WEST SUSSEX COUNTY COUNCIL
INFRASTRUCTURE CONSULTATION

SUBJECT: A/8/09

2 Arlington Crescent, East Preston

Retrospective application for erection of timber gates

PLAN ①

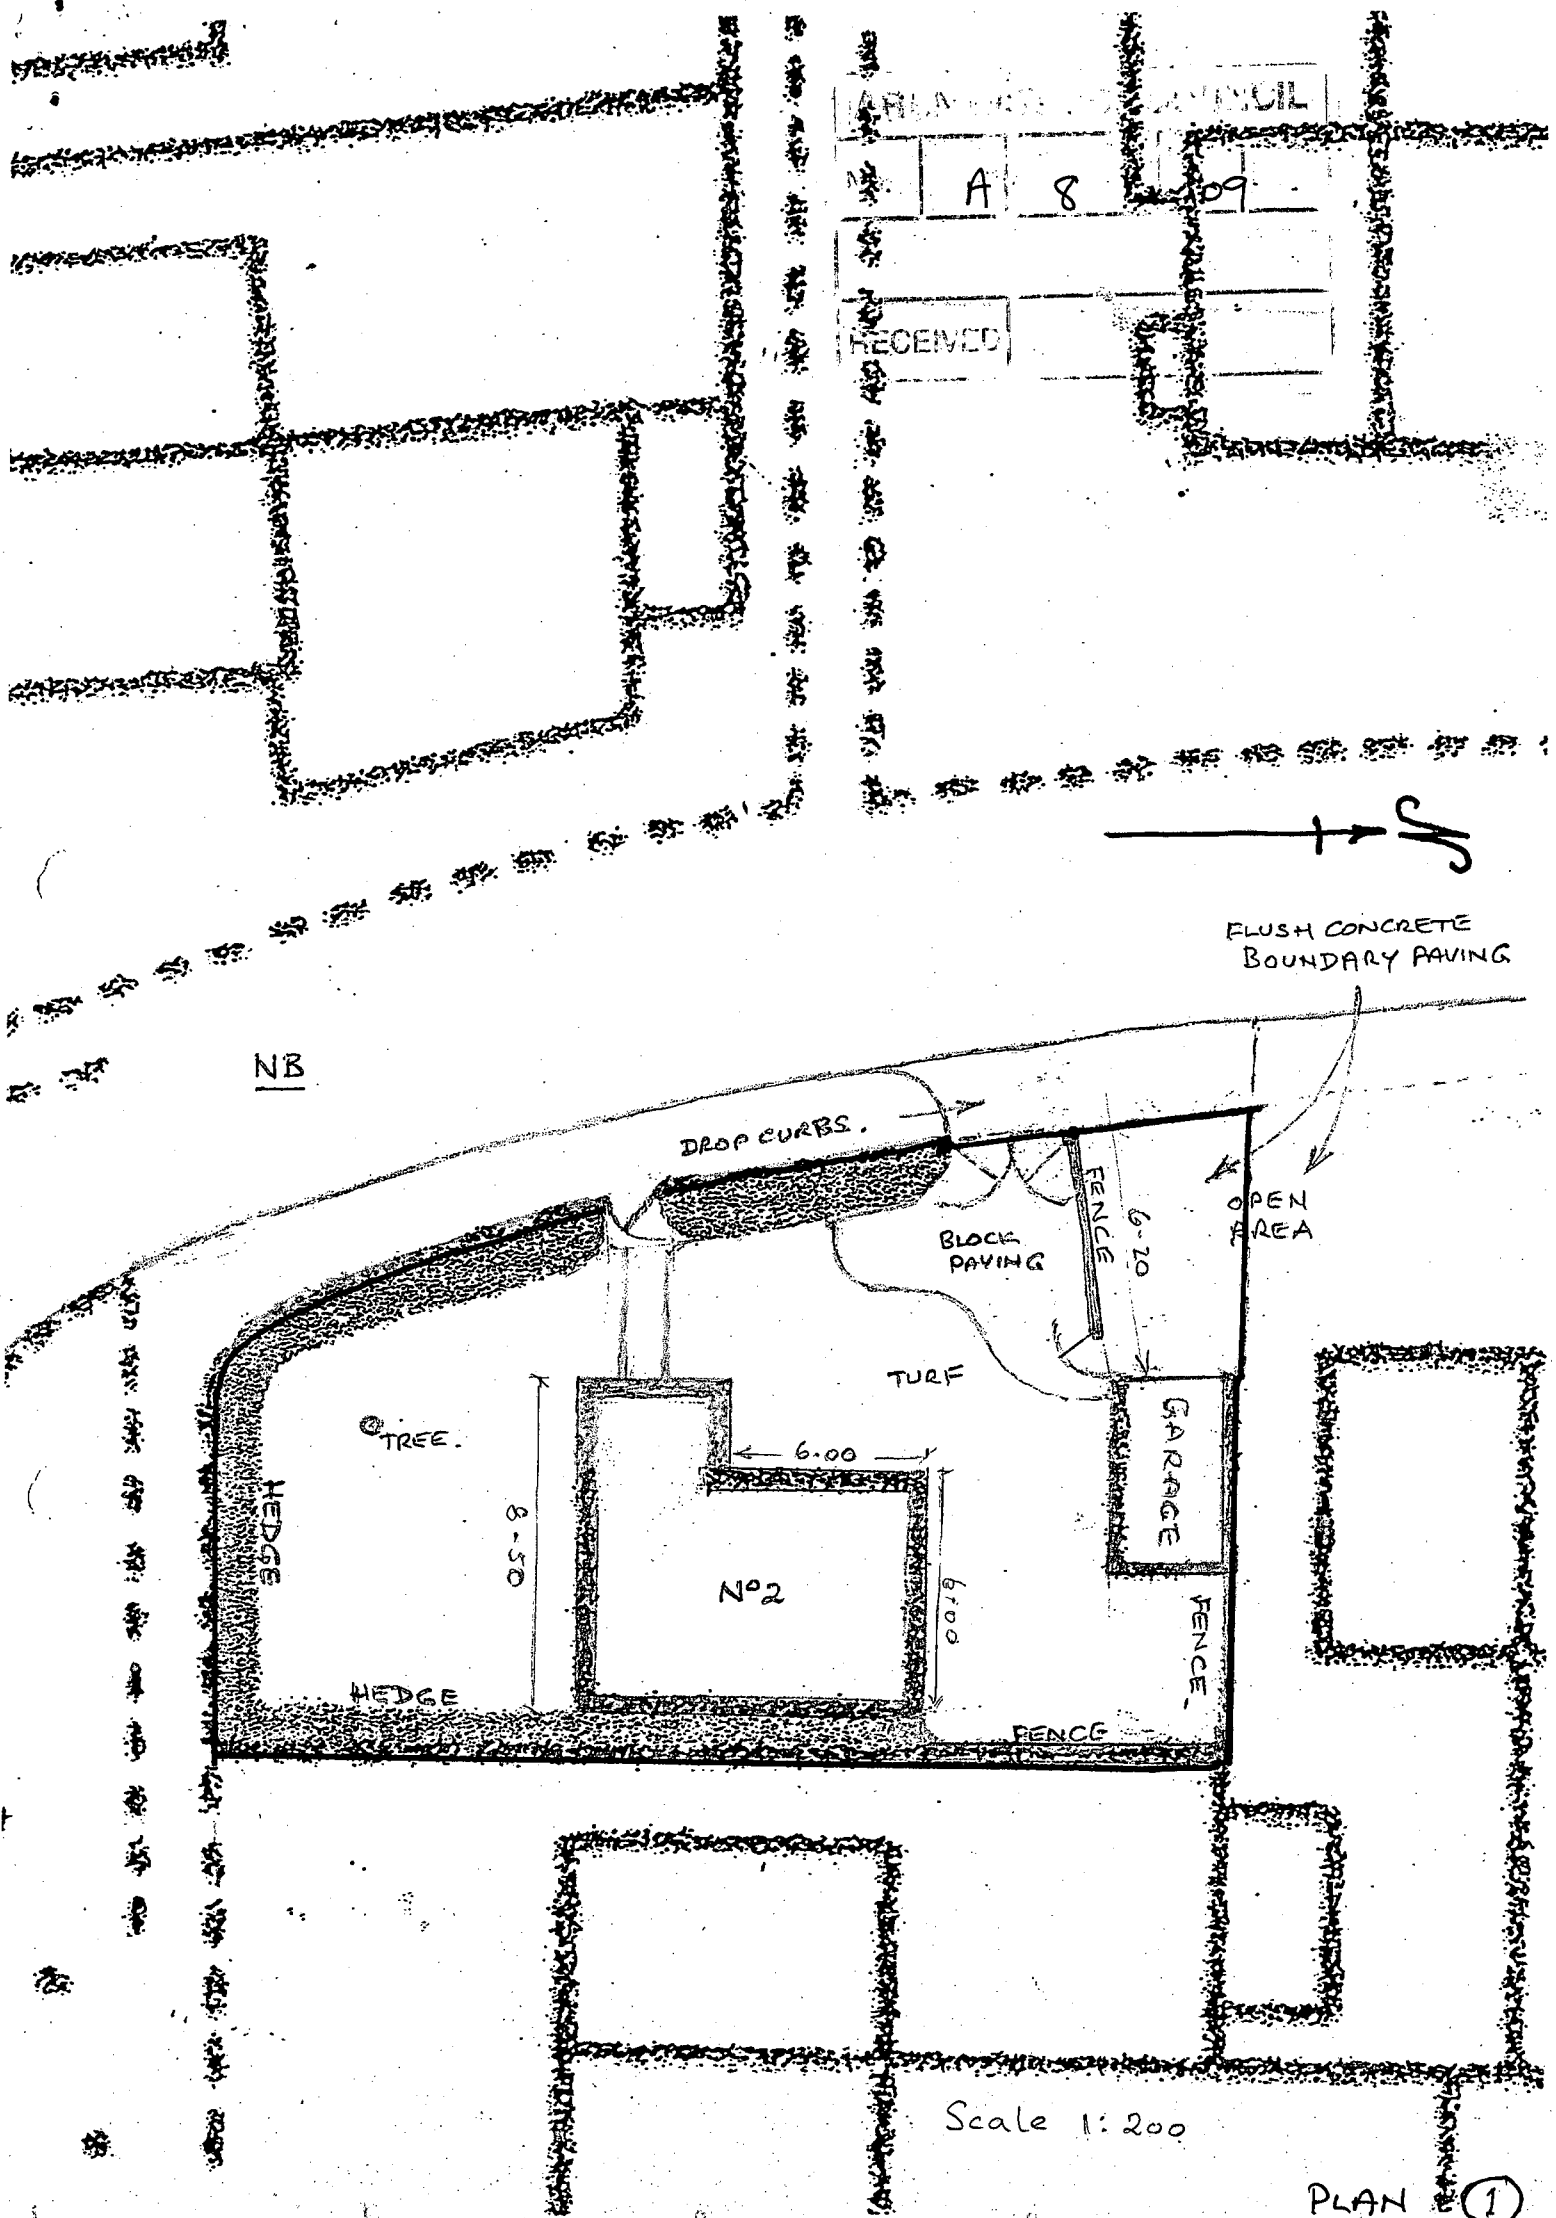
The proposal is for provision of gates with access onto Arlington Crescent. The access point has already been approved by Western Area Office, and therefore no visibility issues are considered. WSCC would prefer that the gates themselves be placed 5m back from the near side carriageway in order for vehicles to leave the highway whilst queuing for the gates to open. However, as the road is declassified and unlikely to carry large volumes of vehicular traffic, and also as the gates are already in place, WSCC has no highway concerns with this application.
